**Final Acceptance Punchlist**  
**El Paso County – Department of Public Works - Stormwater Section**

Project Name:	Redtail Ranch
EDARP Filing Number(s):	SF1821
ESQCP Number:	ESQ1932
Attendees:	DPW SW: Molly Layshock, Mikayla Hartford, Glenn Reese DPW Dev Services: Developer:
Date of Walk-Thru:	05/18/2023
Walk-Thru Number:	1 <sup>st</sup> FA walk

EURV AND WQCV TRASH RACKS:

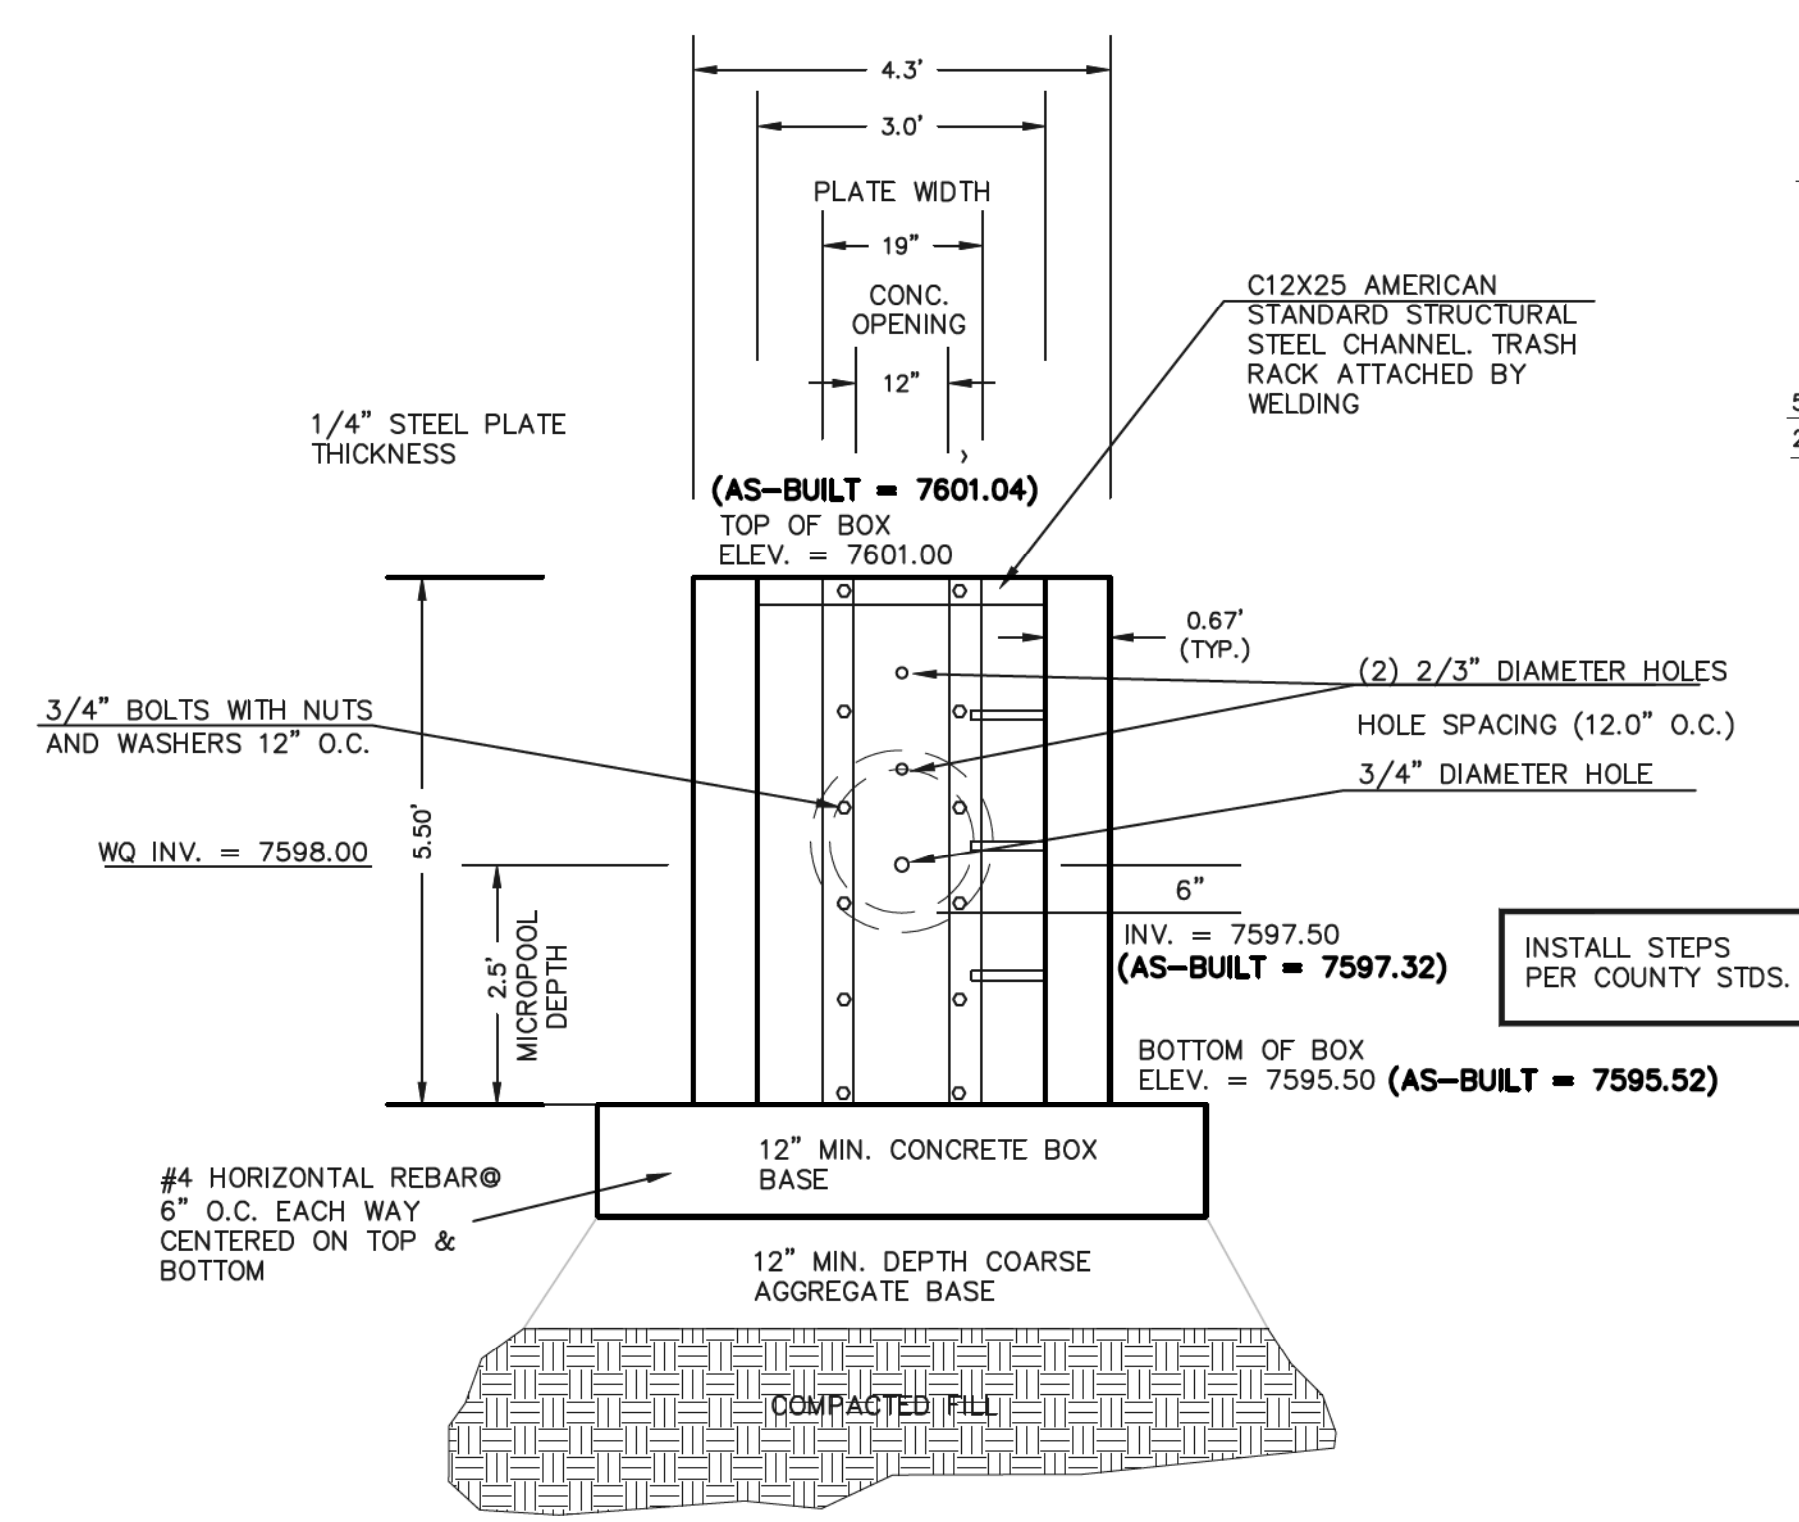
- 19"x60" outlet box orifice plate (sheet 9A of 10) measures 60"x60" in the field. Reflect this change on the as-builts
- Adjust grading at check dams upstream of easterly rundown for positive drainage
